Appeal Decision

Appeal Ref: APP/Z4718/D/16/3161063

107 Thornton Lodge Road, Thornton Lodge, Huddersfield HD1 3SB

- The appeal is made under section 78 of the Town and Country Planning Act 1990 against a refusal to grant planning permission.
 - The appeal is made by Mrs Mussarat Begum against the decision of Kirklees Metropolitan Borough Council.
 - The application Ref. 2016/62/92517/W, dated 22 July 2016, was refused by notice dated 23 September 2016.
 - The development proposed is a first floor rear extension.
-

PROPOSED ELEVATION

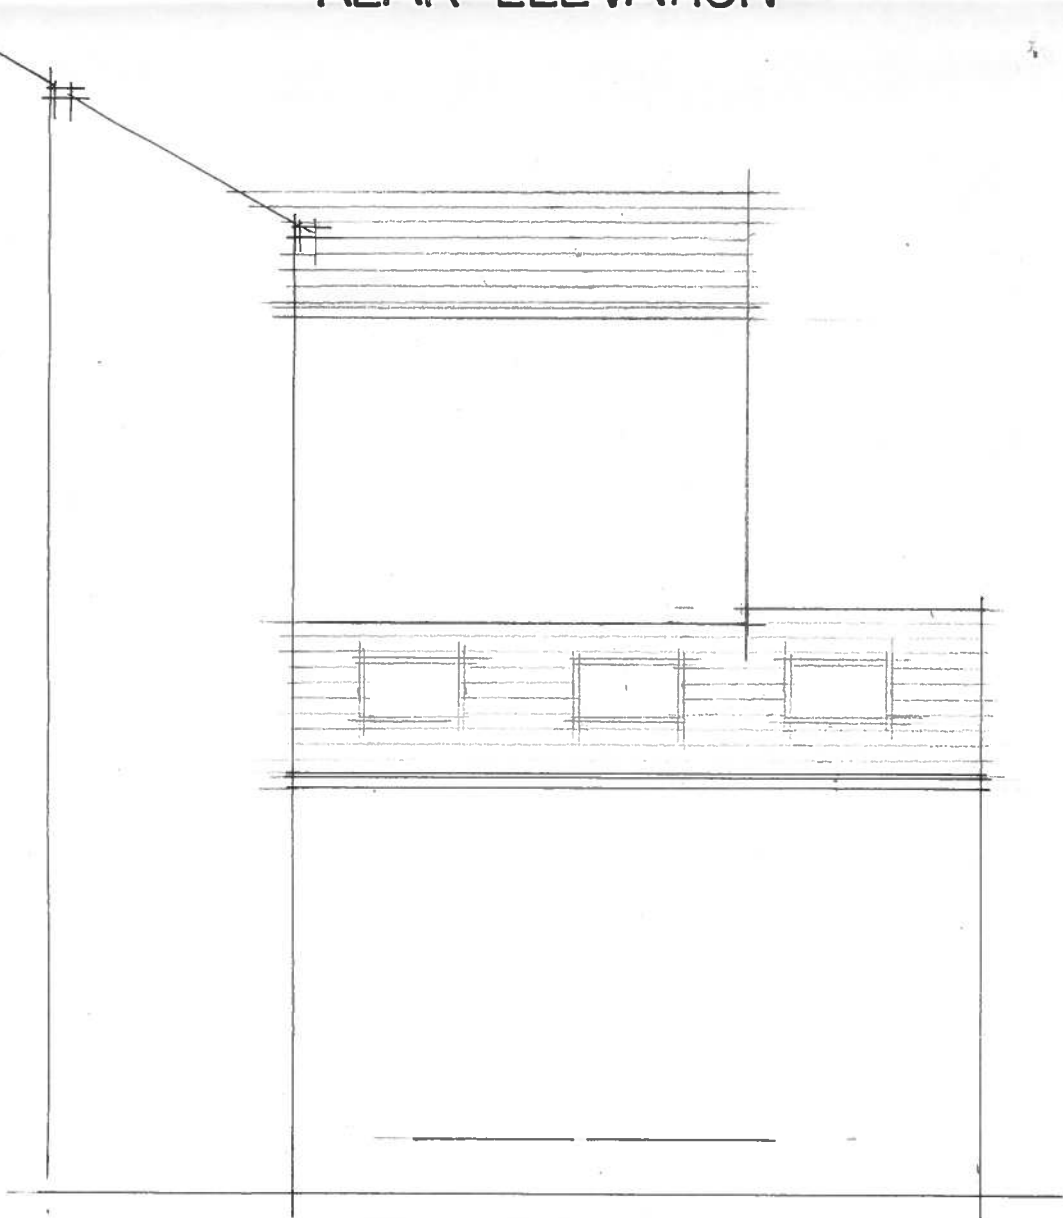
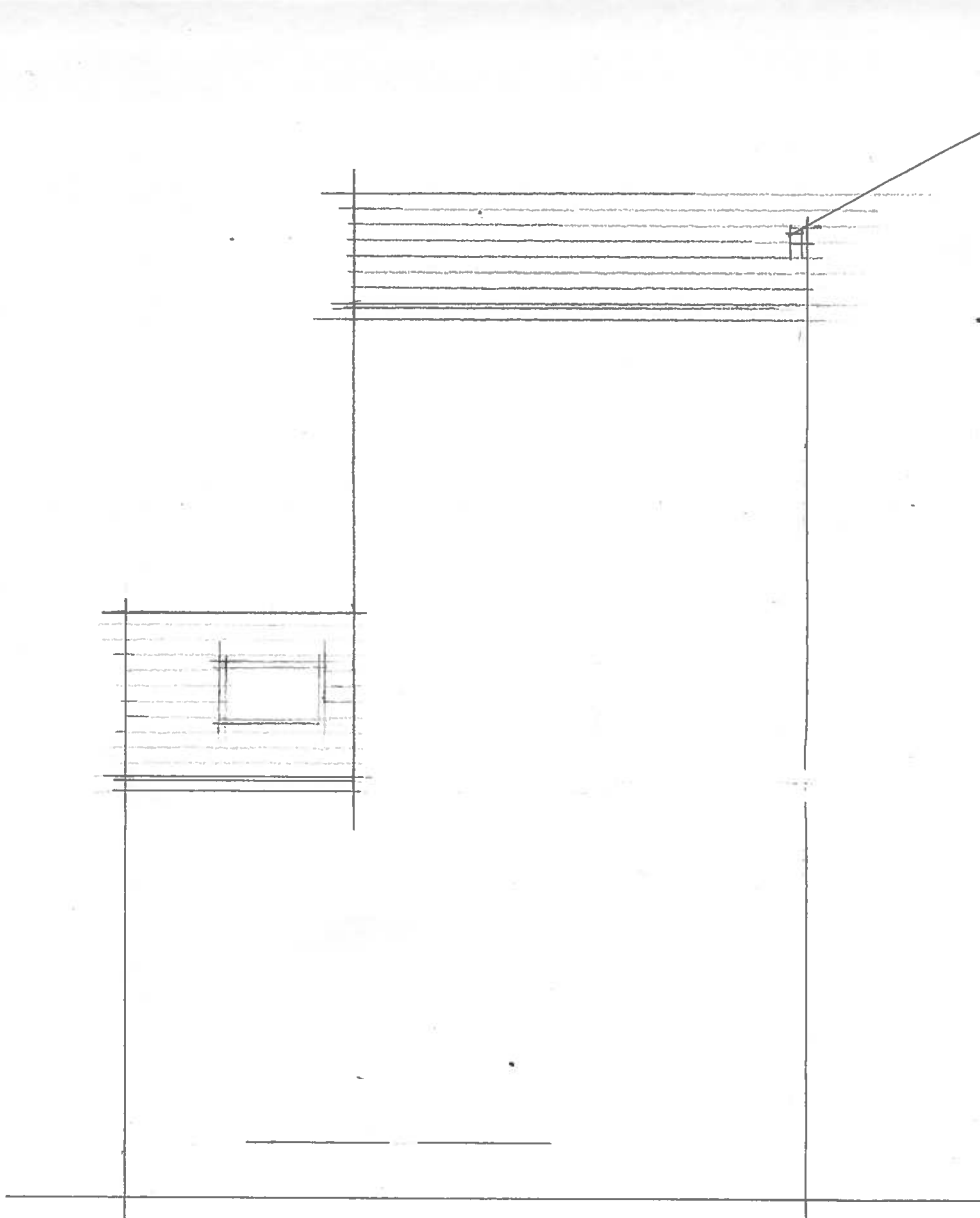
4. The appeal site comprises a two-storey mid-terrace dwelling of stone construction under a slate roof. The proposed extension would adjoin an obscure glazed first floor bathroom window serving No 105. The window immediately abuts a large two-storey extension to the host property which no doubt reduces the amount of daylight and sunlight reaching the bathroom. The proposed extension would result in built development to each side of the window opening and would further diminish light to the room. Although the neighbour has not objected and it is not a habitable room where occupants are likely to spend a great deal of time, the reduction in daylight and sunlight would unacceptably harm their living conditions.
-

6. No 6 Yews Hill Road is situated at right angles to the terrace, so that the ground and first floor windows in the property face the appeal site at relatively close quarters. The proposed extension would dominate the outlook from these openings and create an oppressive living environment for the occupiers. Daylight and sunlight levels reaching these windows would also be reduced, but not to the degree that the occupiers' living conditions would be appreciably harmed.

PROPOSED FIRST FLOOR

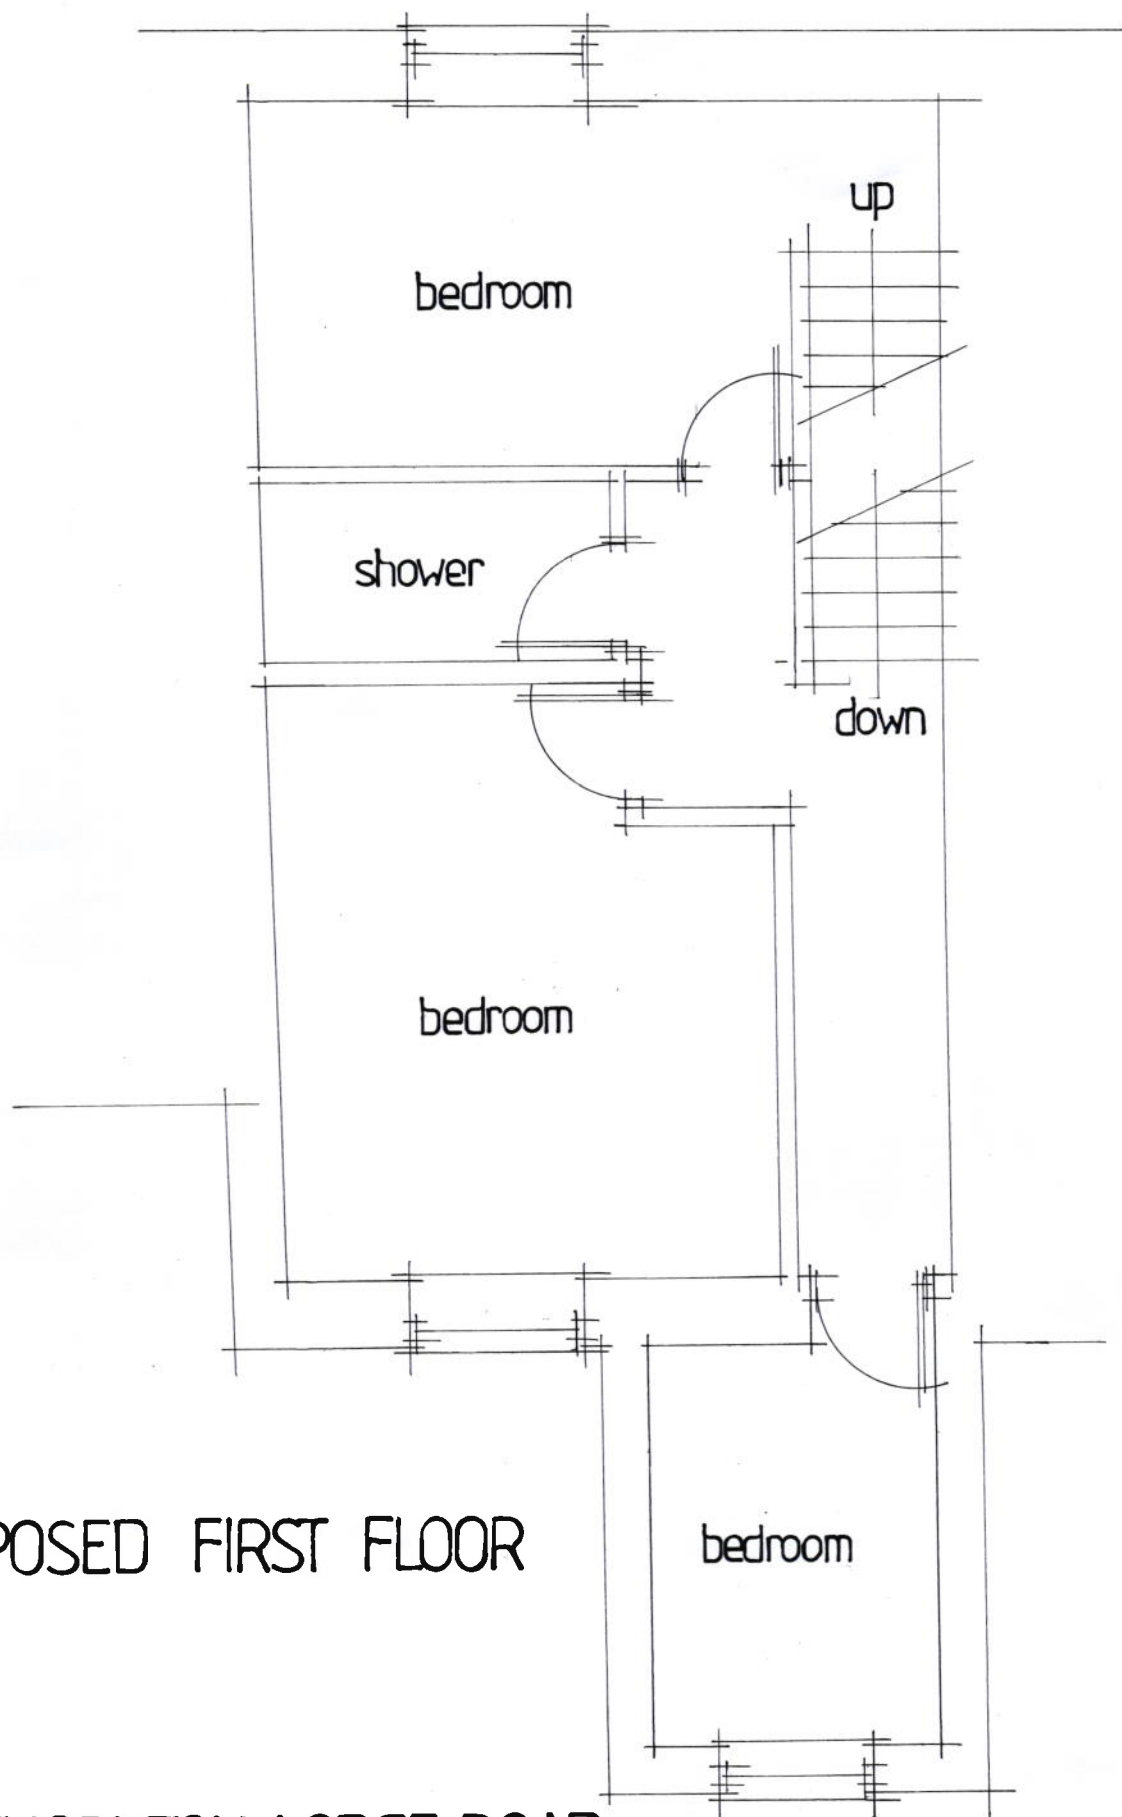
2. The refused drawings show a two-storey rear extension to the appeal property providing a ground floor kitchen/diner and a first floor bedroom. There is no dispute between the parties as to the acceptability of the single-storey element of the scheme, which the Council advises is 'permitted development'. I am satisfied that this aspect of the proposal would cause no material harm and would not conflict with any development plan policies I have been referred to. I shall therefore confine my detailed considerations to the proposed first floor rear extension.

5. The adjoining dwelling to the south (No 109) has windows to habitable rooms on the rear elevation. However, it is set back from the appeal property and the new extension would be set in from the common boundary by some distance. As a result, the outlook from these windows would not be materially compromised and the daylight and sunlight reaching the rooms would not be significantly diminished. The extension would, however, increase the sense of enclosure for users of the amenity space to the rear of No 109 and reduce daylight and sunlight levels to this area, to the detriment of the occupiers' living conditions.
